Highways and Transportation

Application - DA/23/01325/FUL

Location - 108 Havelock Road

Proposal - Demolition of existing dwelling and erection of detached 5 bedroom house with landscaping and dropped kerb

Drawn by:	Scale:	© A1	Date:
HD	1 : 100		31.10.2023
Drawing number:	BL/DRG/20231031/ O-2.12		Rev:
Dimensions to be checked on site.

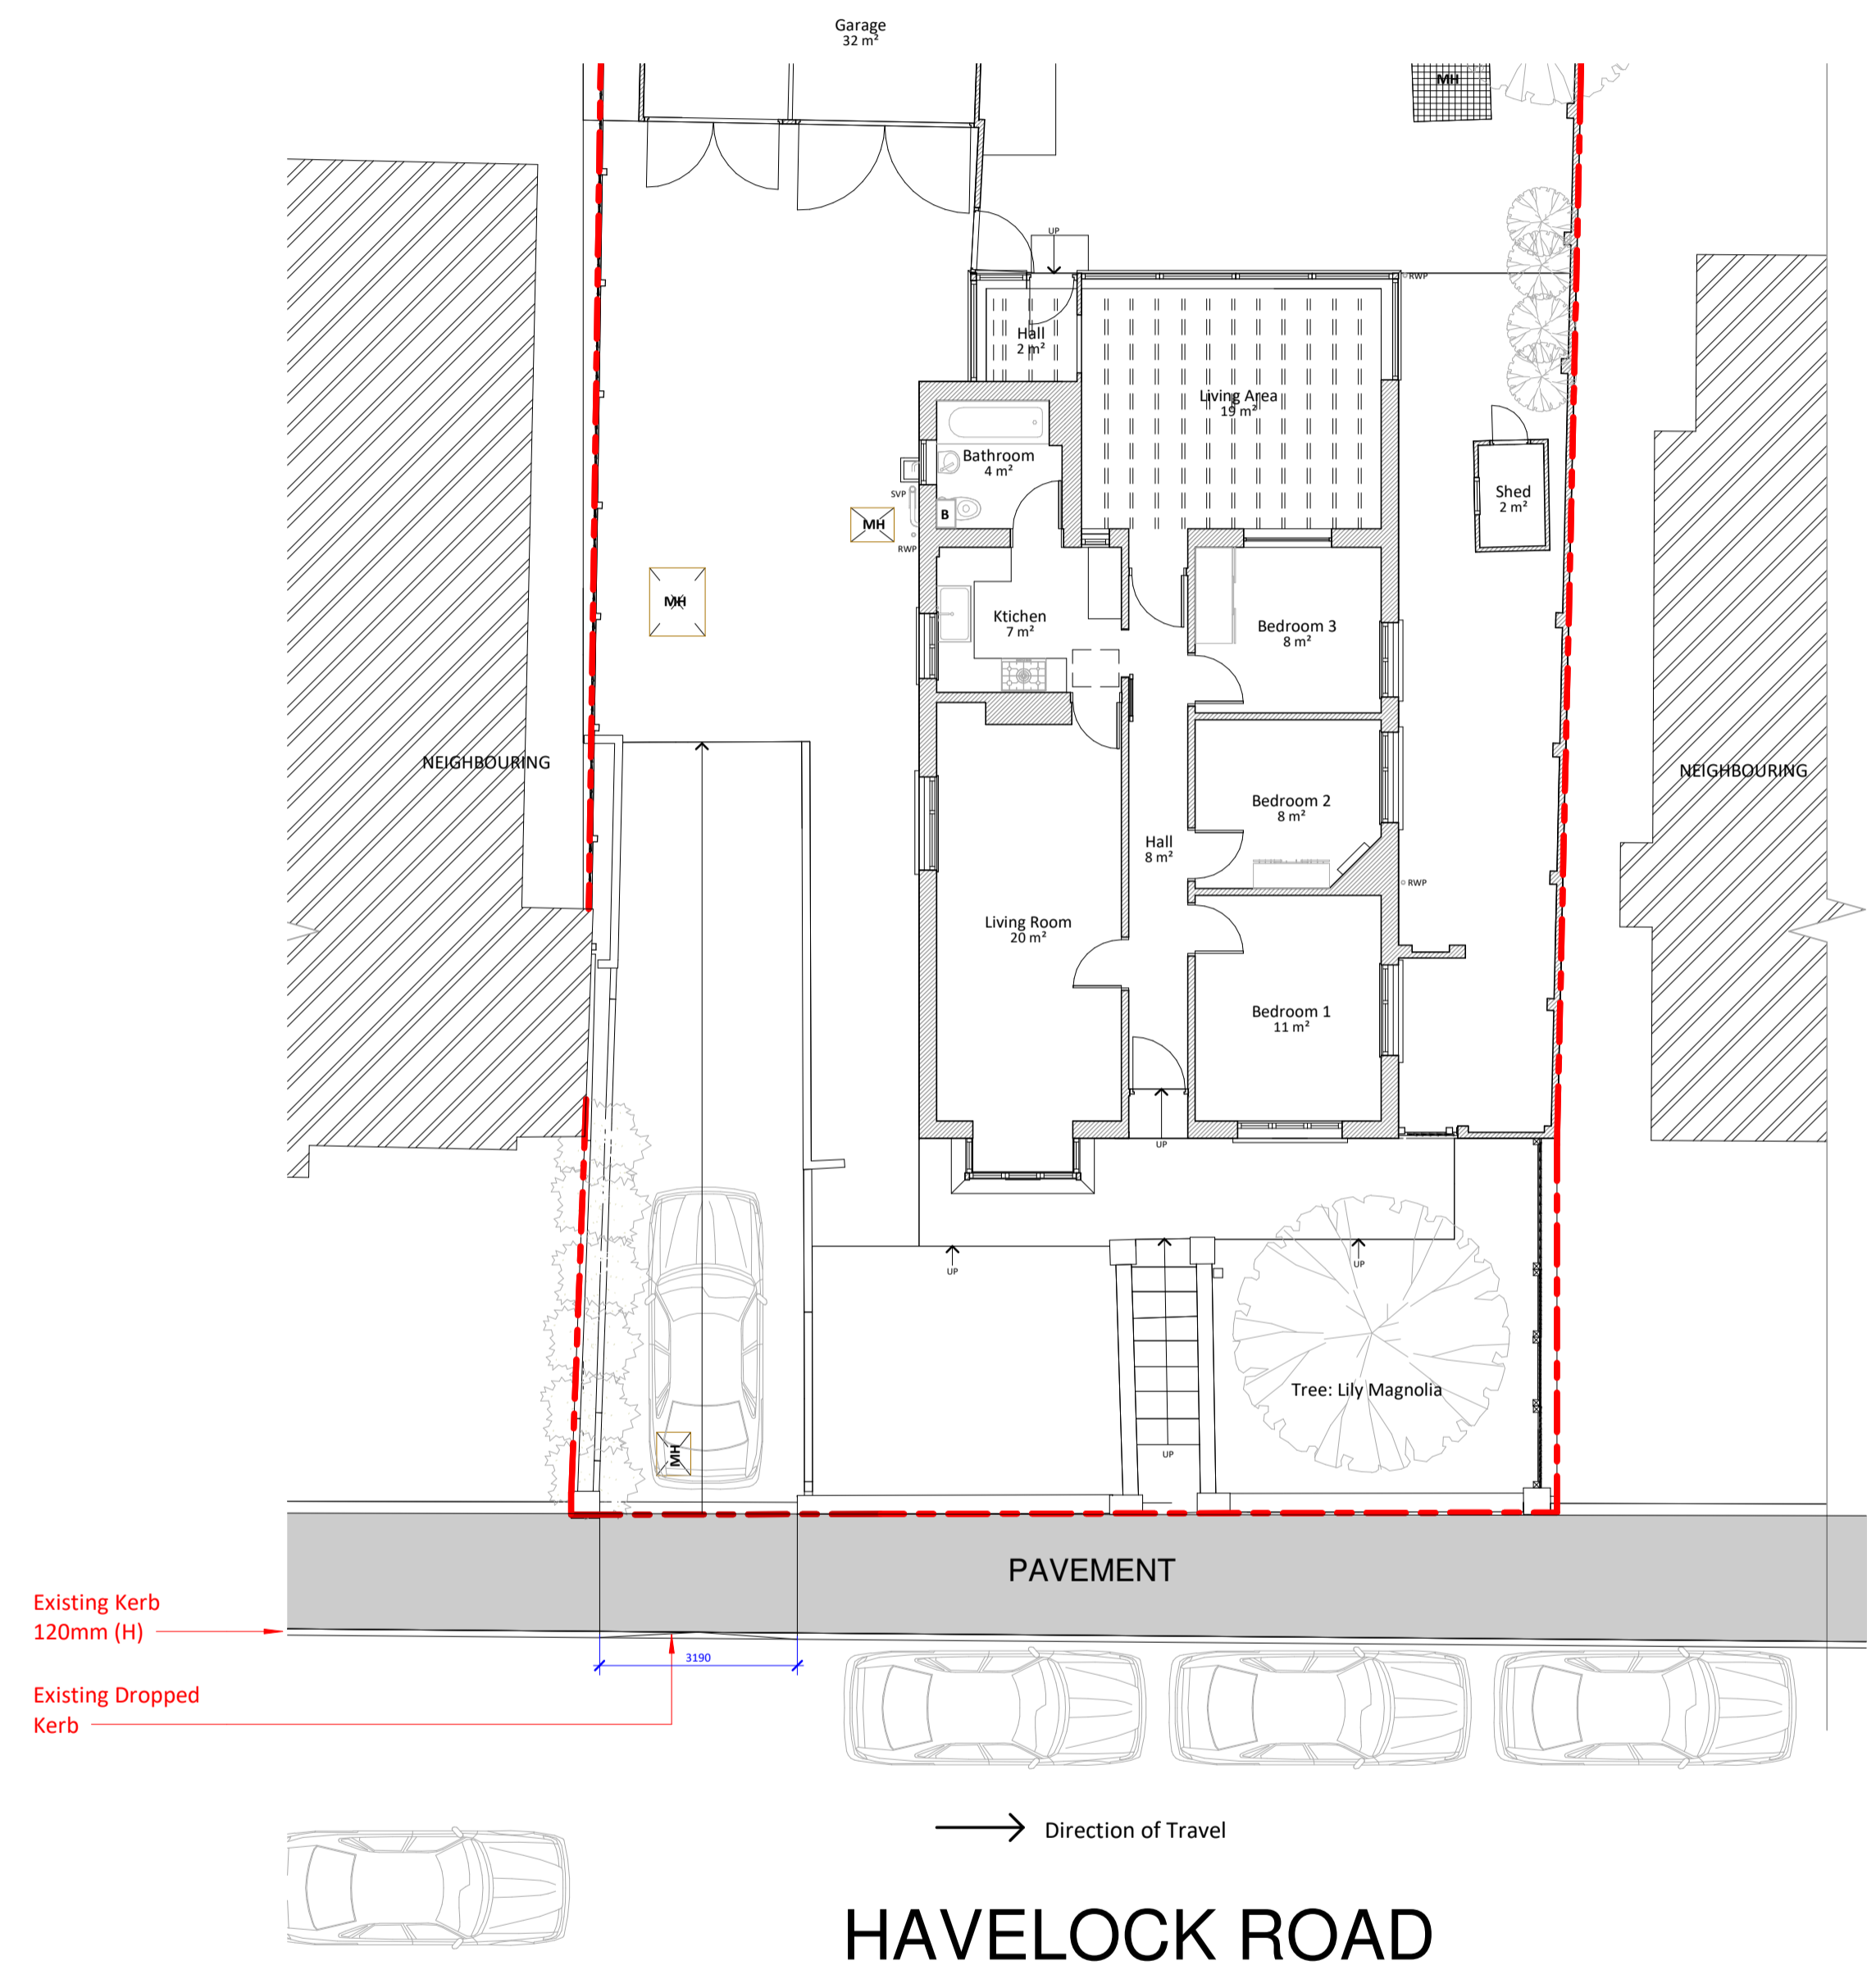
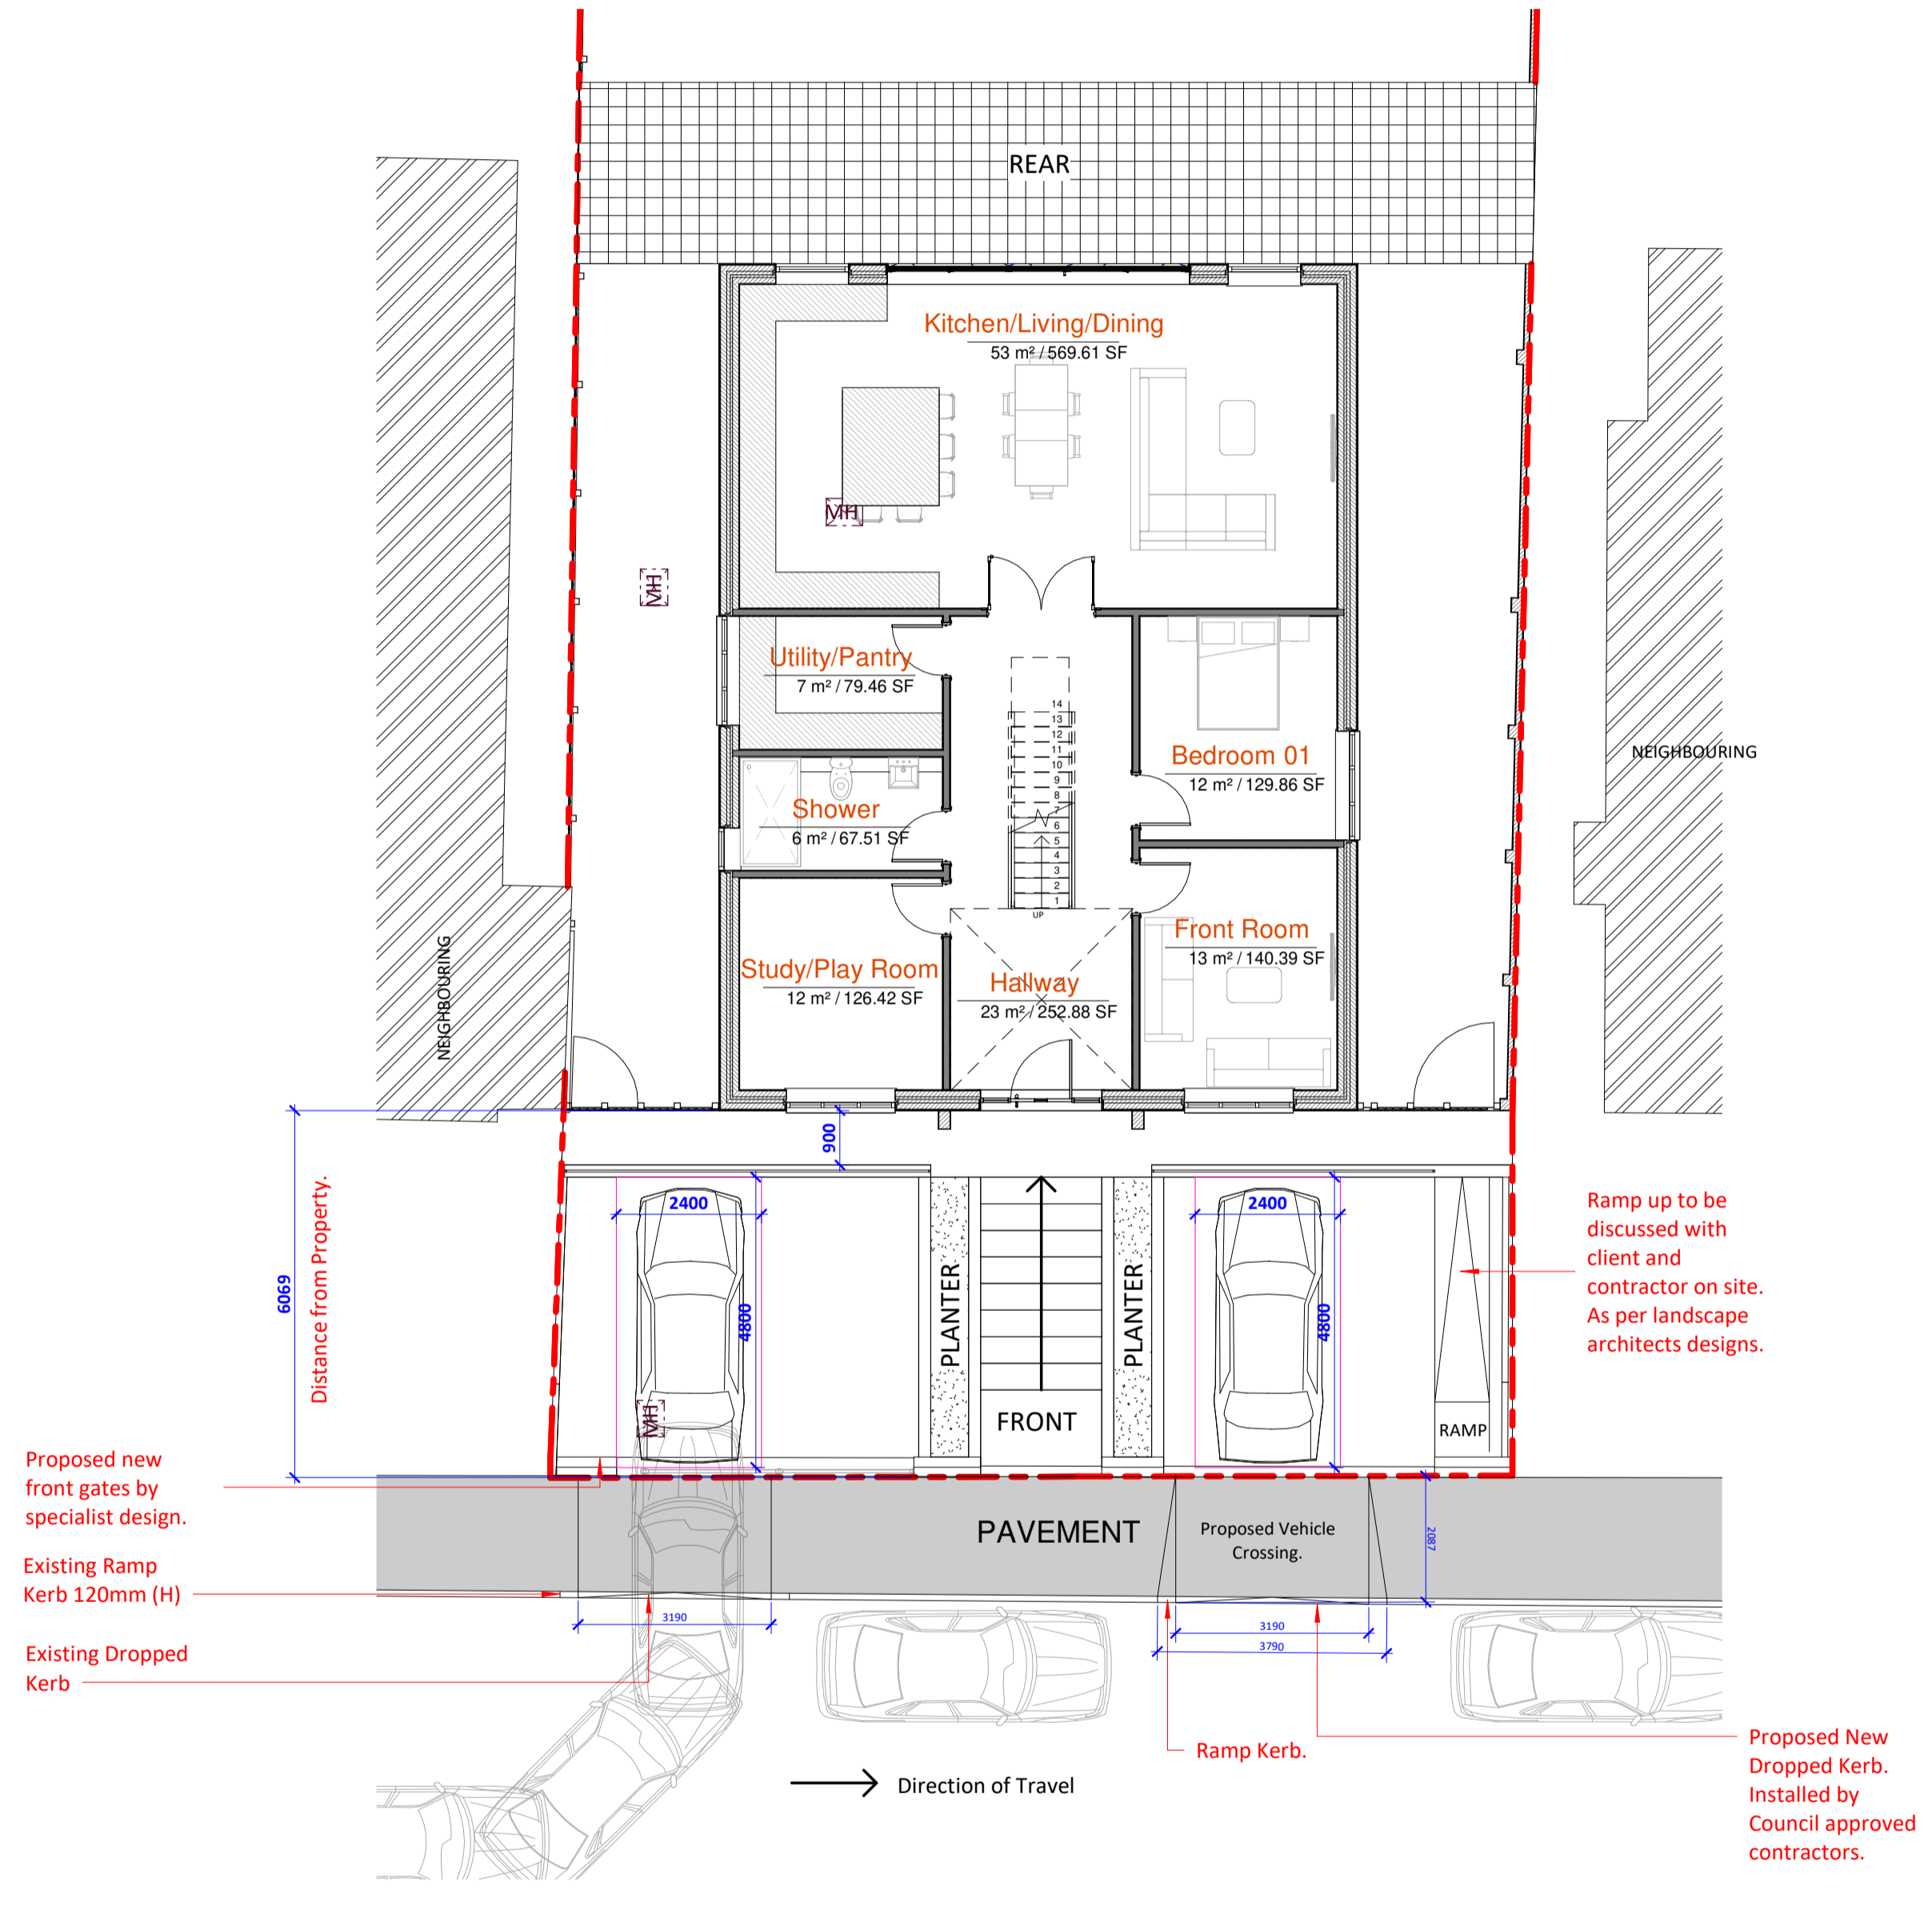
It is noted that this would usually be a non-protocol application, however the proposals include gates to the parking area which are immediately adjacent to the public footway (as shown on drawing BL/DRG/20231031/O-2.12). Any gates to dwellings must be setback a minimum of 5.5 metres from the carriageway to prevent vehicles stopping on the carriageway and consequently the inclusion of gates to the parking area for this application is not acceptable.

Provided the parking areas for this property are not gated, and the appropriate level of cycle storage is included within the proposals, then on behalf of the local highway authority I confirm that I raise no objection to this application. Should either of these requirements not be met it is expected that the highway authority be re-consulted.
